Please upload the email below and the attached revised landscape plans from the applicant onto Ocella for LU/305/19/RES.

We have received the revised LEAP design back from our Landscaping consultant based on your previous comments you submitted to us from the Landscaping Officer objecting to our previous proposal – please see below the consultation notes.

#### LEAP

LEAP Design

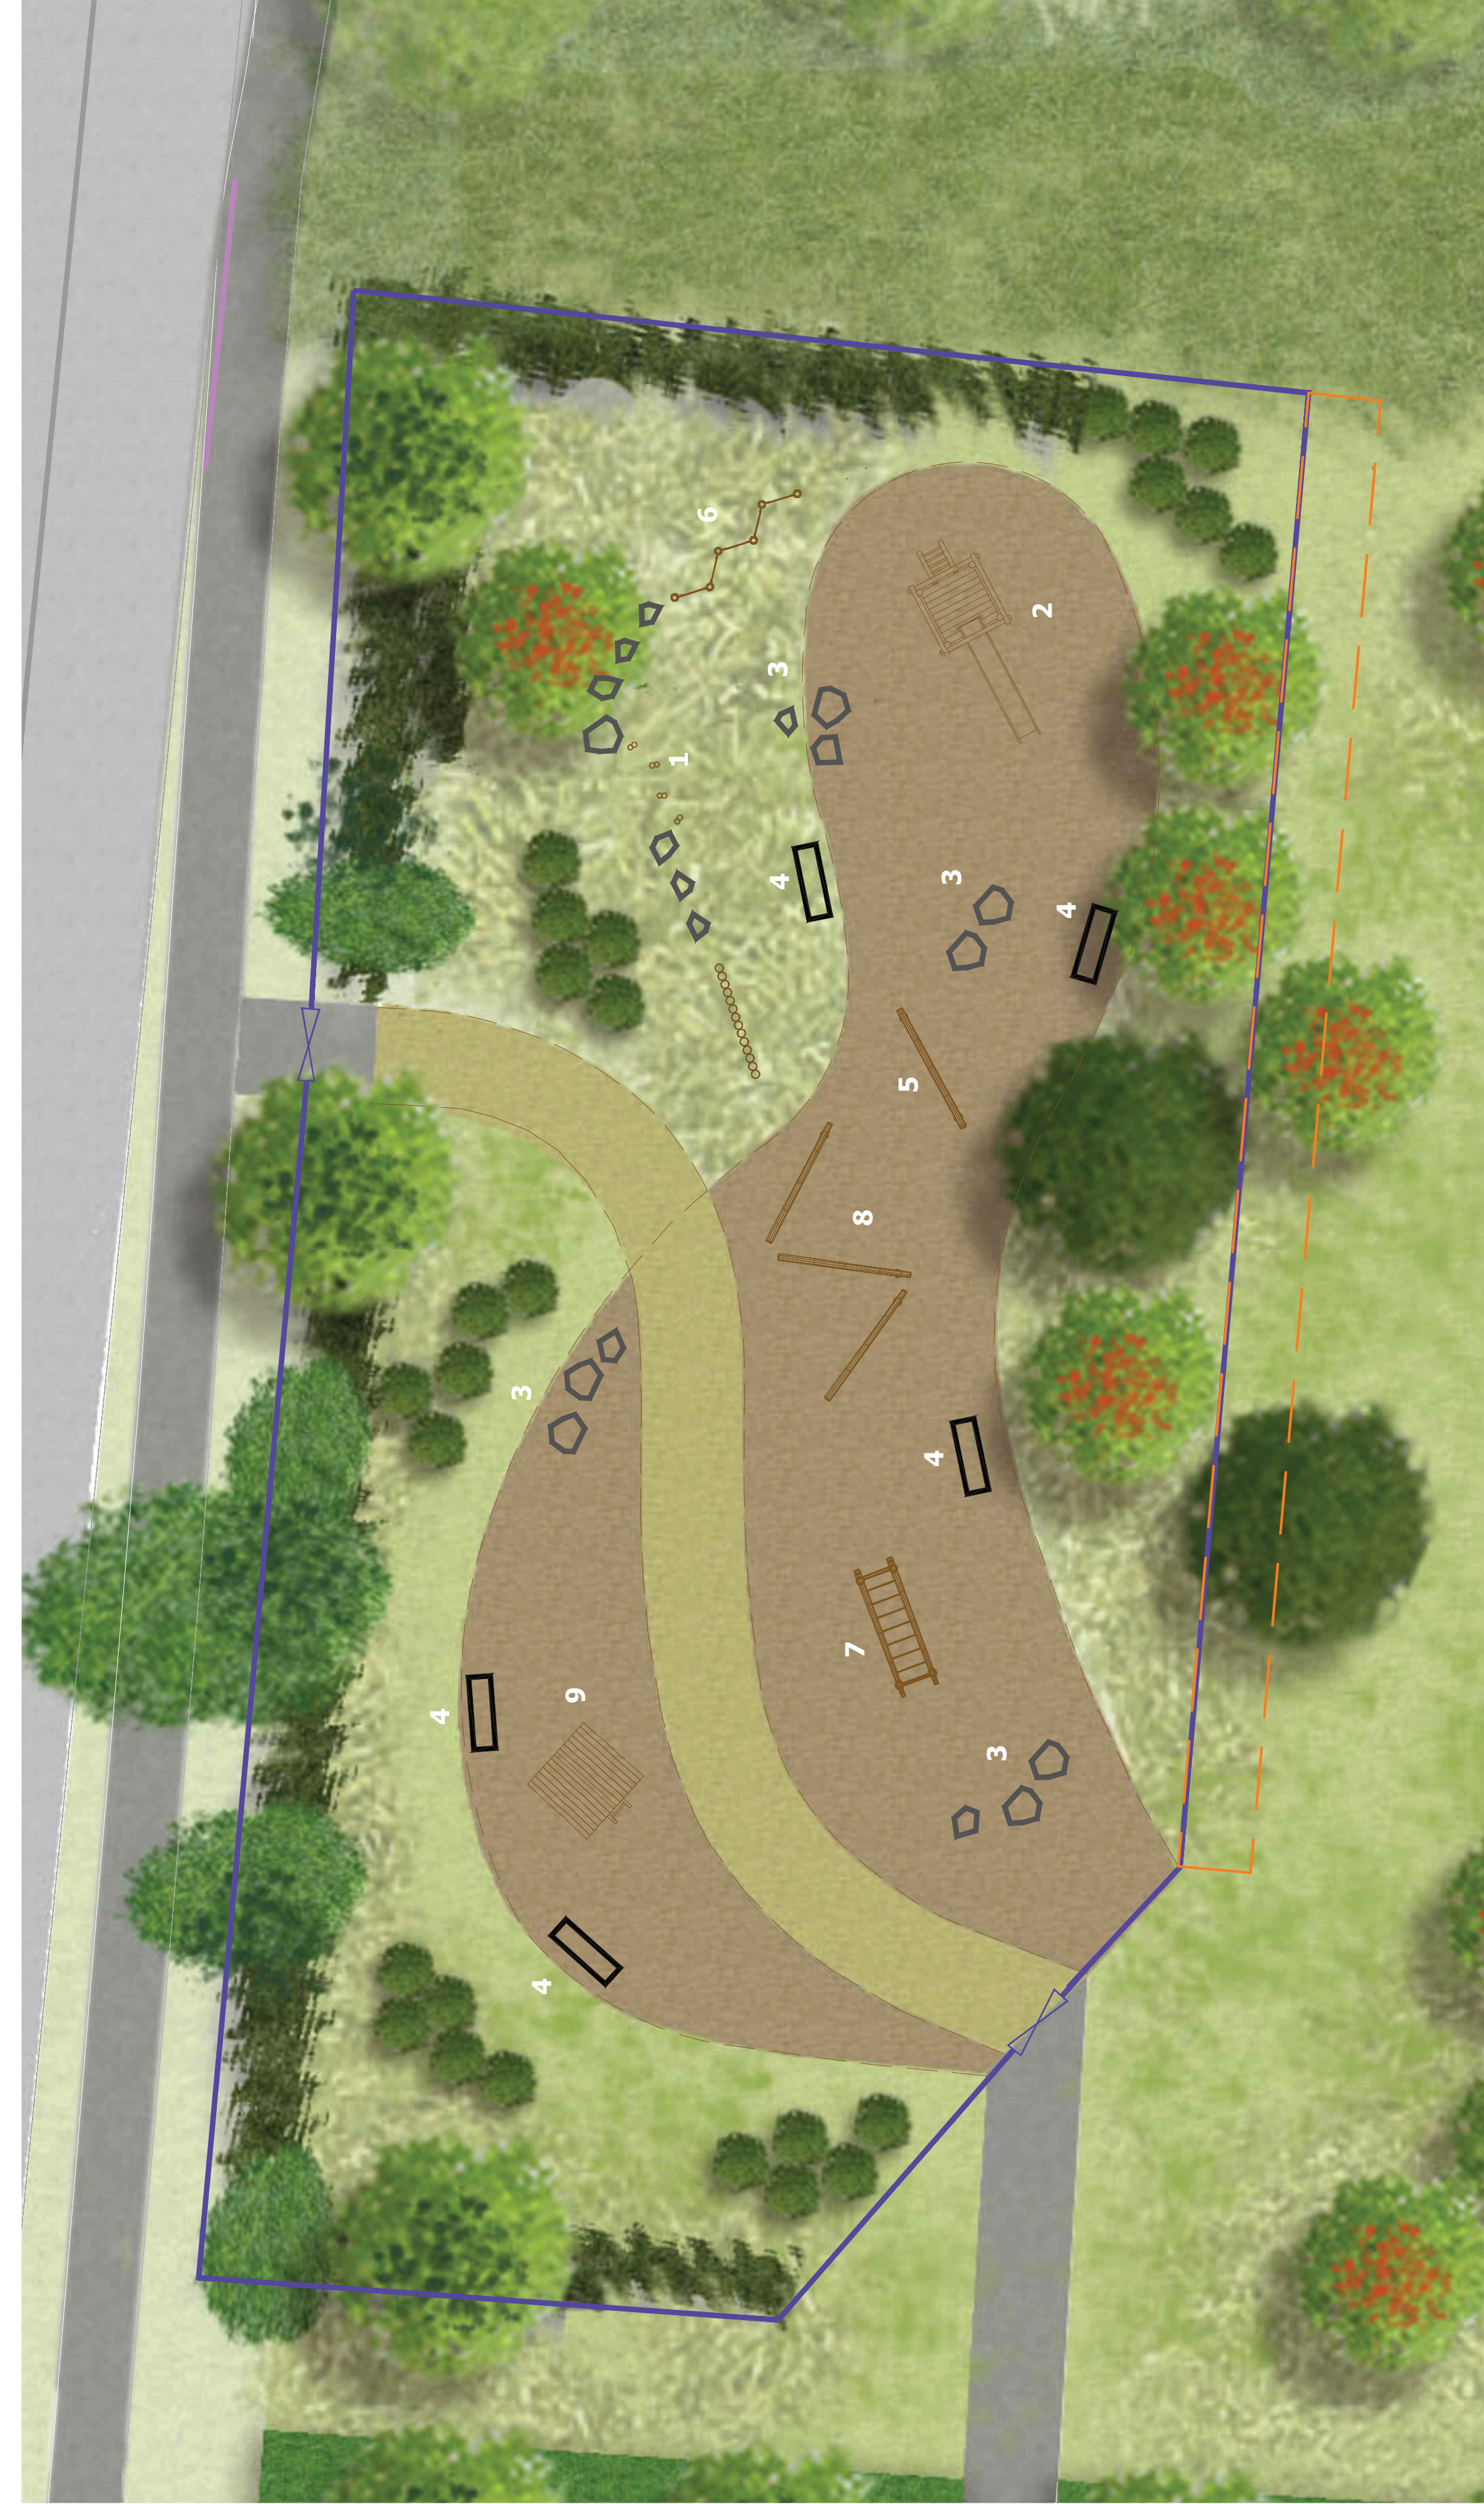
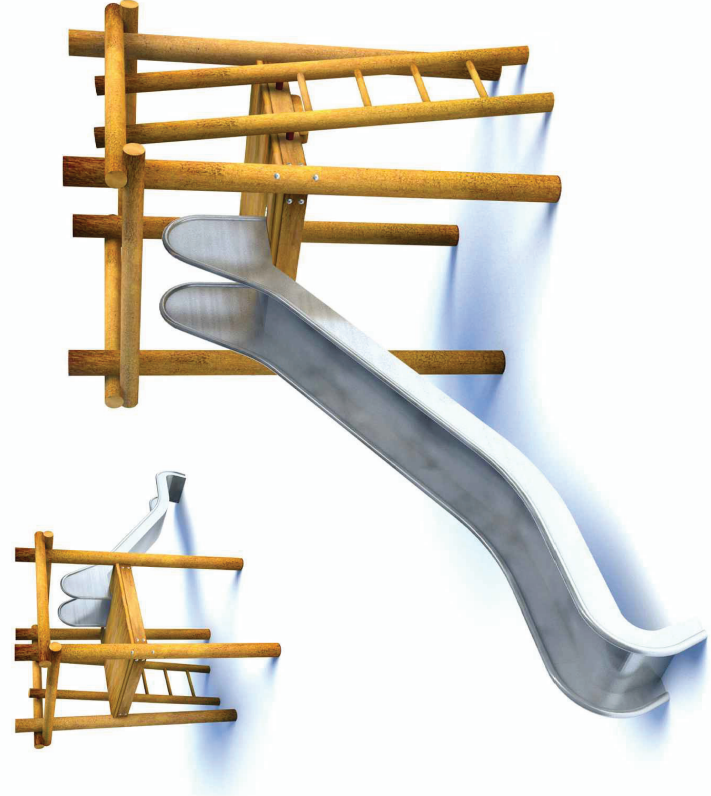
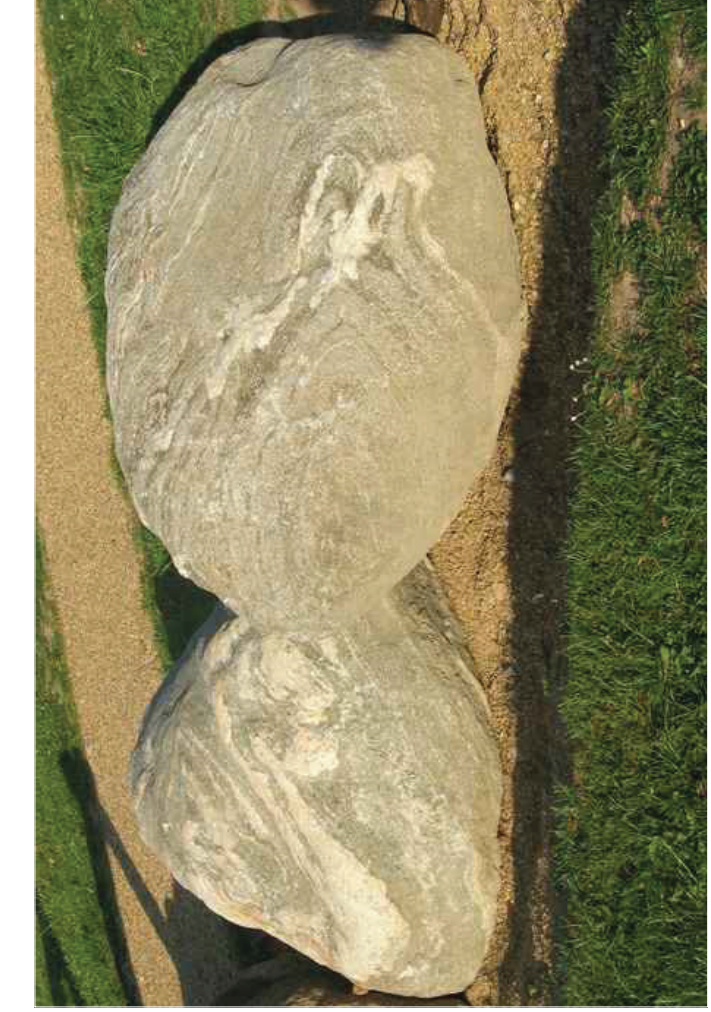
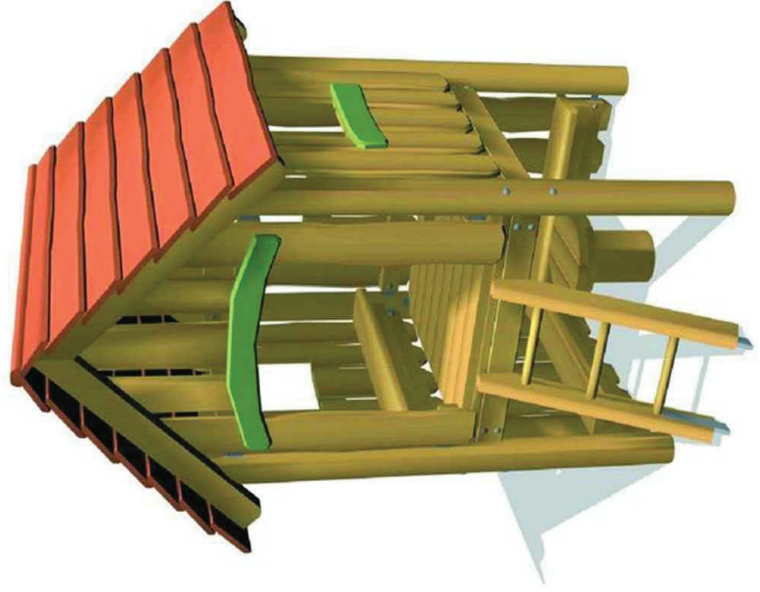
LEAP design Dwg LA 303 REV L LA 300-303 (L) has proposed a spacious and well located play area, however the play offer contained would appear to be too limited in play experiences proposed. The play has focused largely on climb and balance and whilst the choice of material – wooden is good and the items themselves ok, due to the limited experience being offered I would recommend that swing, spin, twist possibly rock are incorporated into this LEAP design. My understanding is, that as this was to be a double LEAP- due to under provision on another phase then the incorporation/substitution of further play experience here is imperative. I would like to see this additional play in the same material palette which is good and suitable for location. I would add a note of caution re the safety surfacing being bark mulch as this has the tendency to provide maintenance issues going forward, but defer to your play advisors for consideration. Pathway, gates and seat, good to see incorporated, the addition of a litter bin would also be useful to see. One of the access gates would need to be accessible for maintenance operations.

We would have to advise that I would **NOT recommend the approval** of reserved matters on this application LU/305/19/RES relating to LEAP until the points I have raised above have been considered and addressed.
